Amendment: Window detail amended
(Dwg no. 2041-2)

Planning Application H13/1236/00.

Erection of a single storey part two storey rear extension, 3 Fengate, Moulton Chapel - Mrs Lockie.

DATE
SCALE
JOB NO. 2041 ~ 2

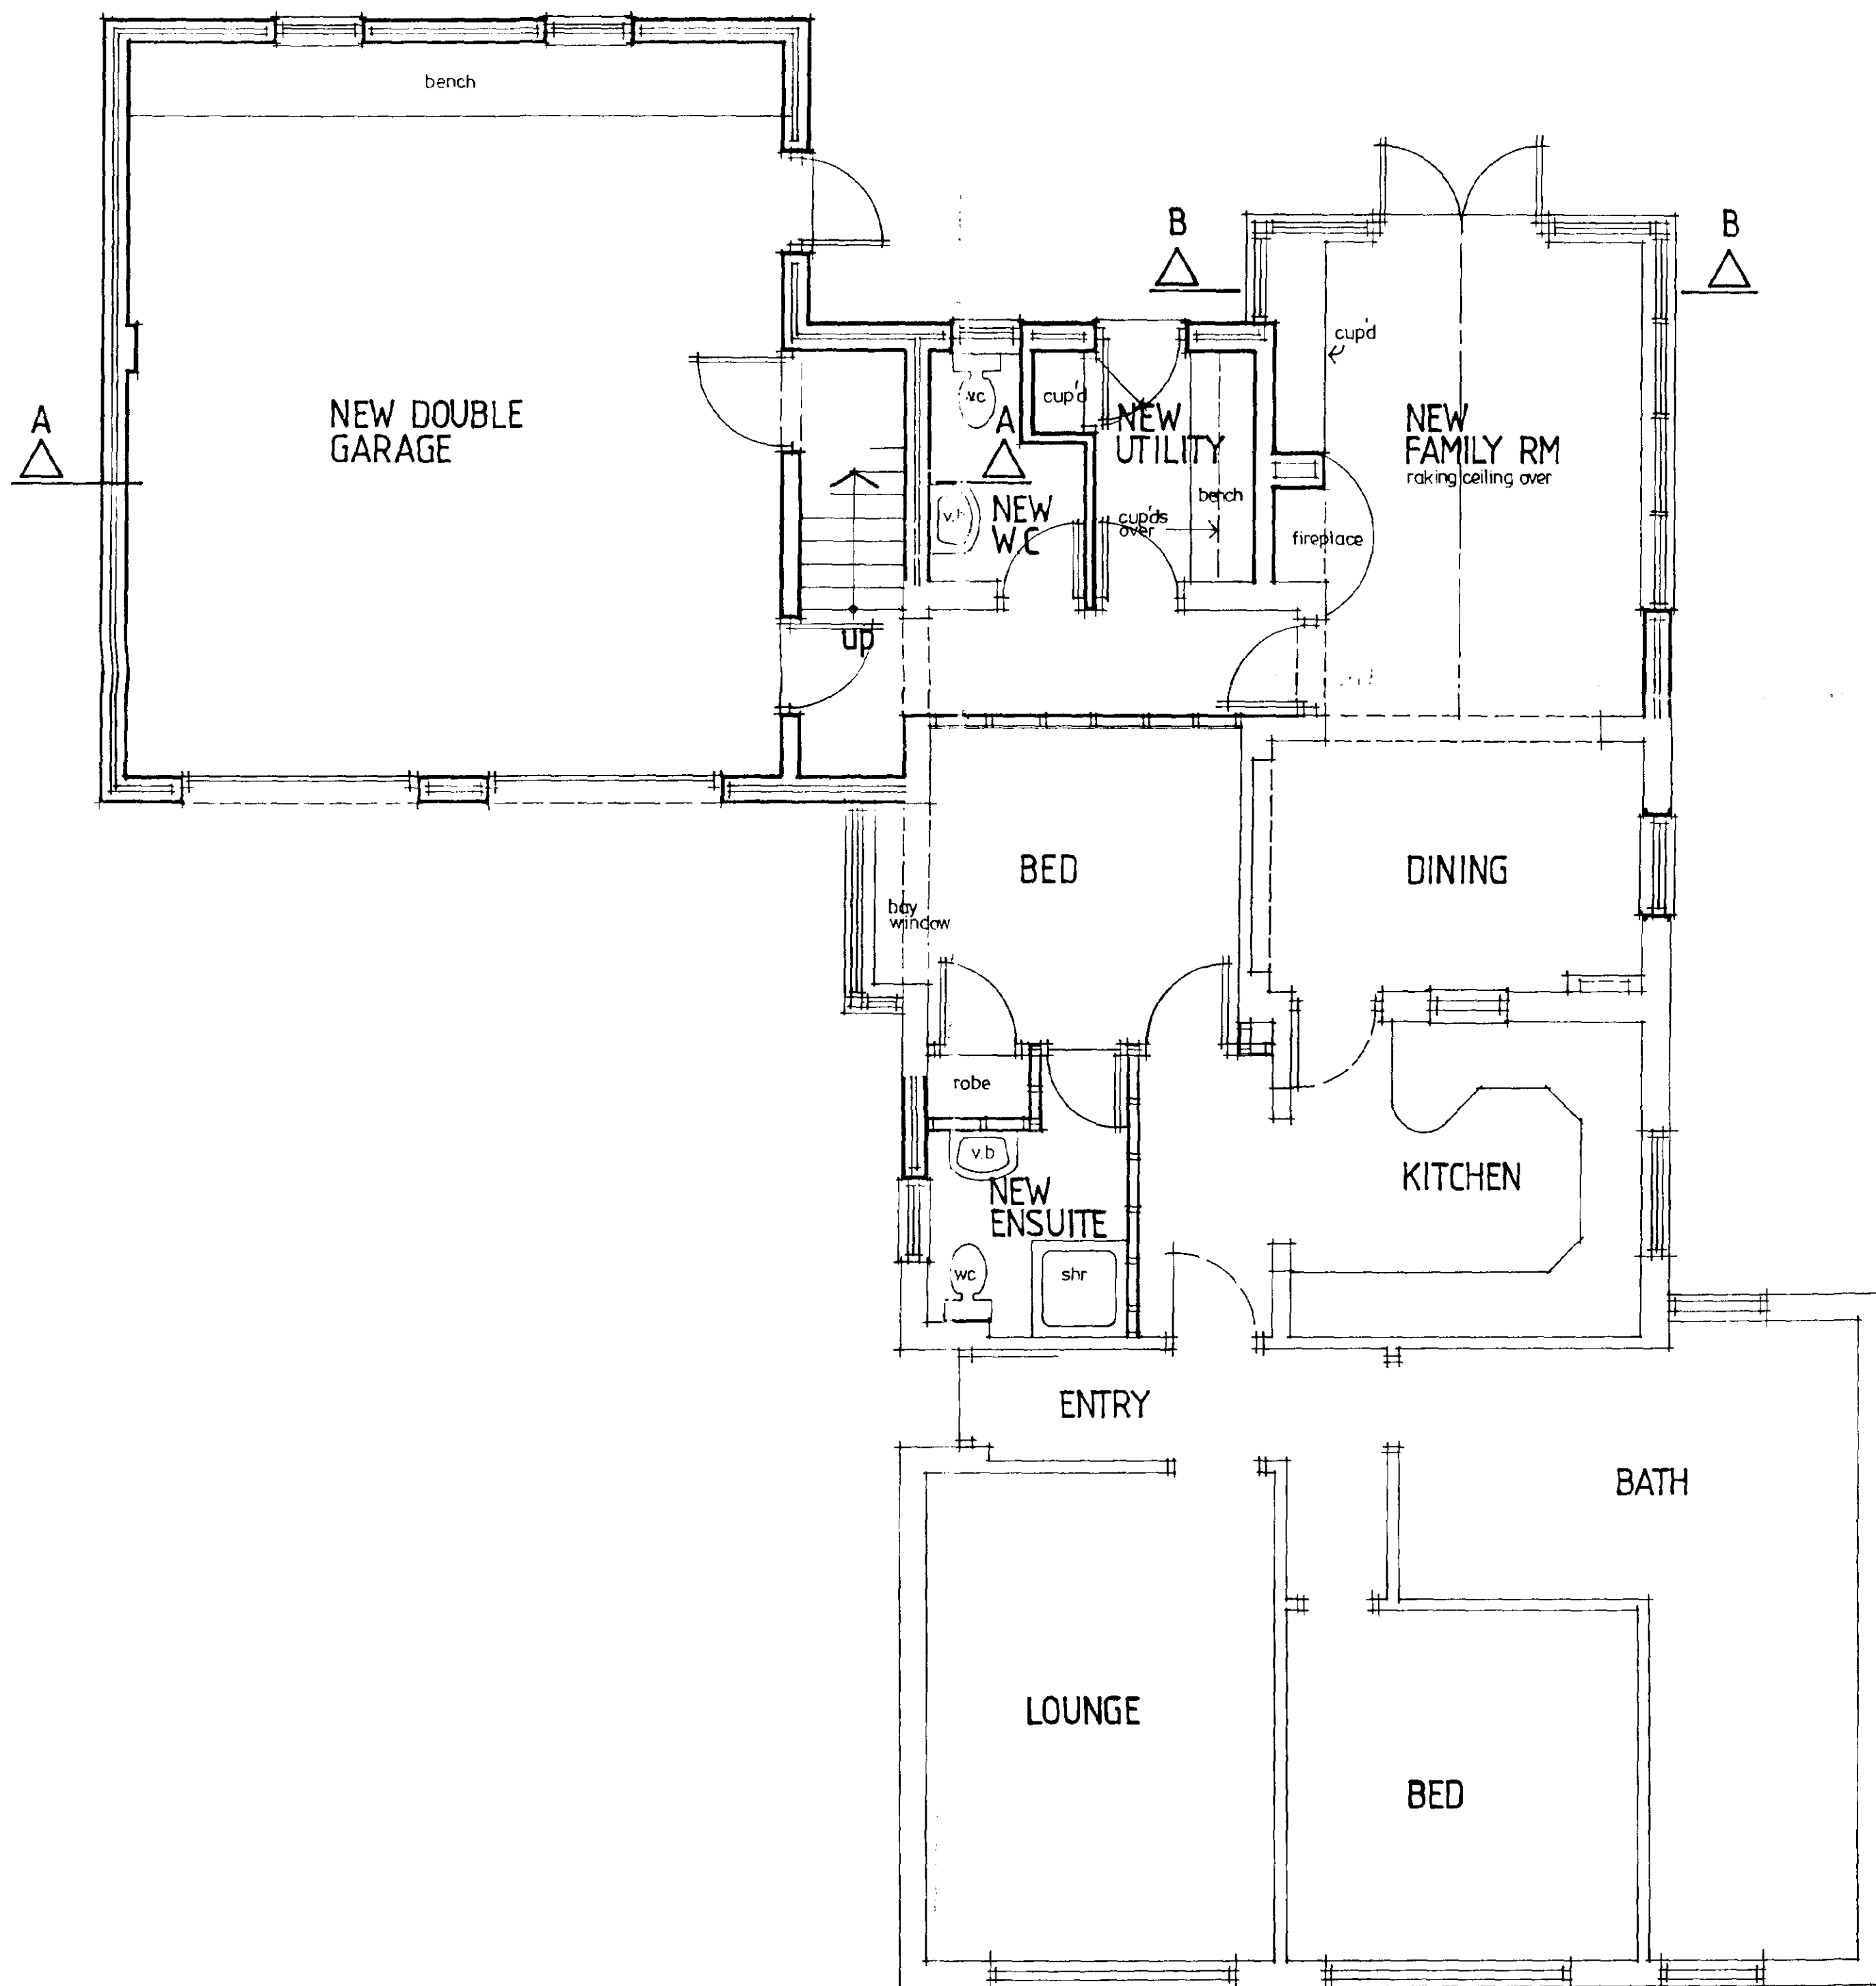
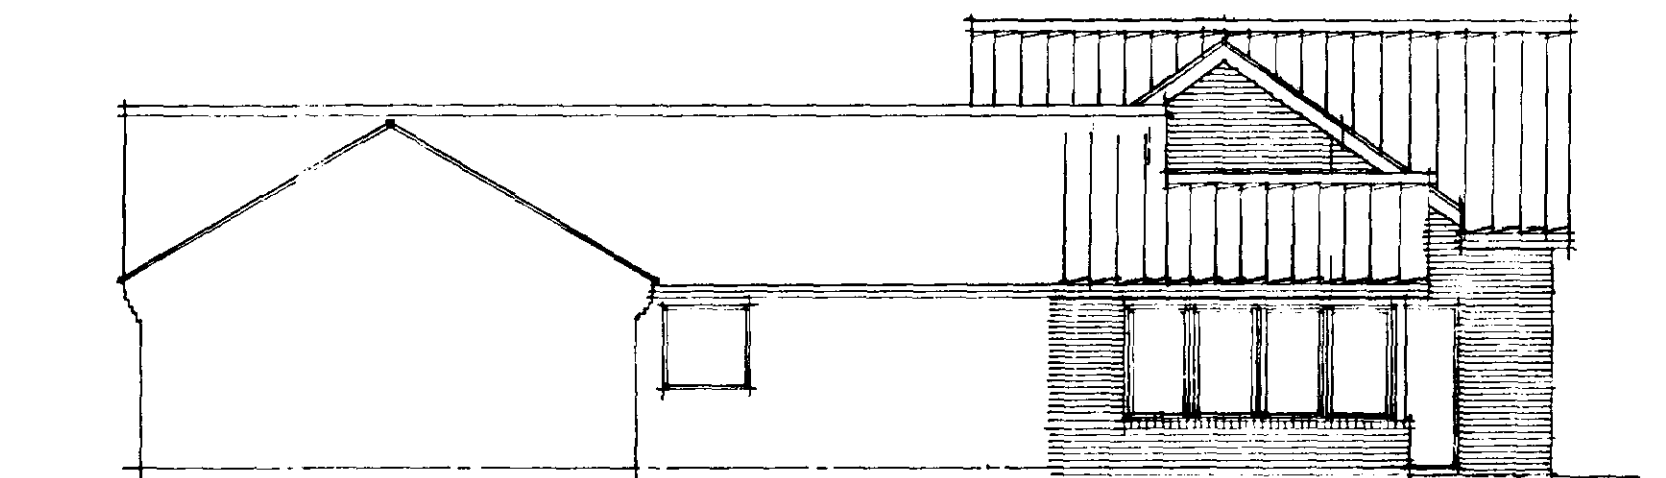
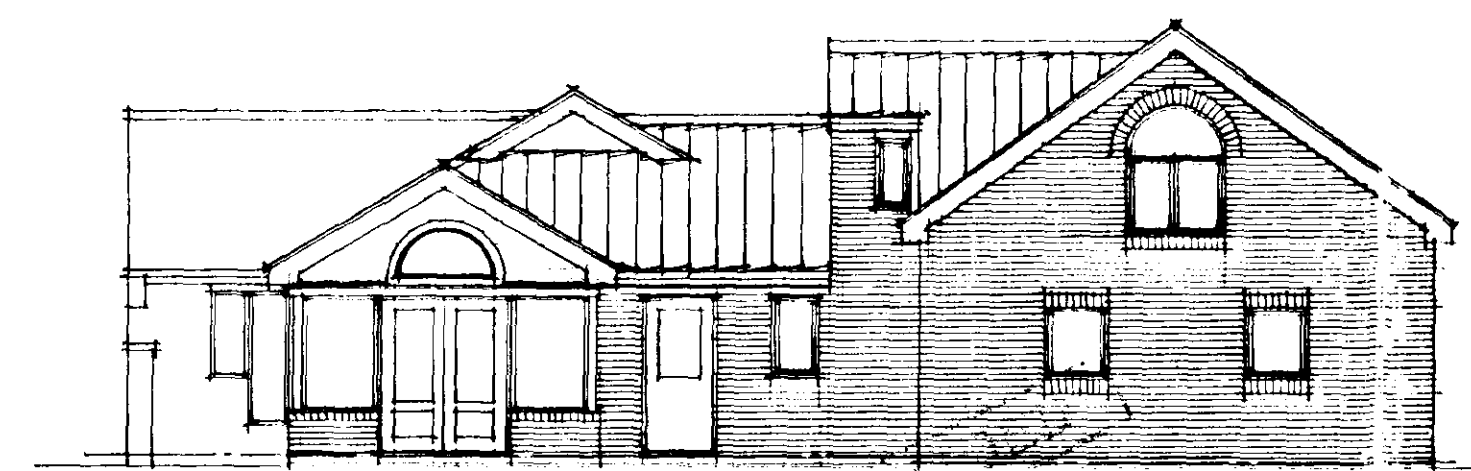
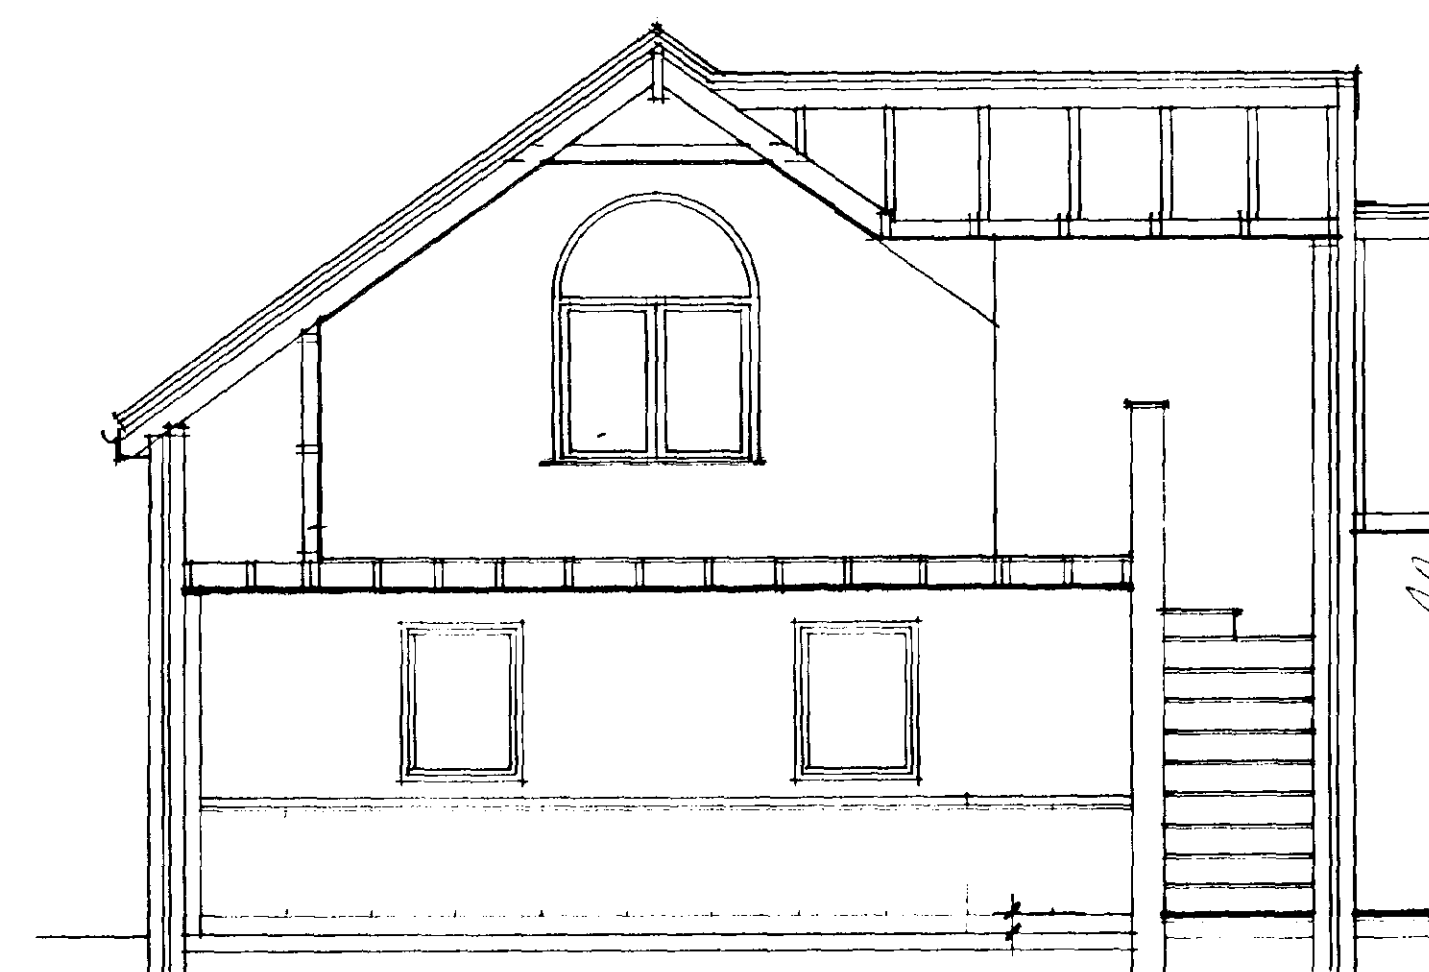
It is noted that the proposed extension has a new rear window at first floor level. This is in relatively close proximity to the eastern boundary and as such would overlook new development presently under construction.

It is therefore considered that this window should be deleted. If you need an alternative light source no objections would be raised to the provision of roof lights, preferably on the southern elevation.
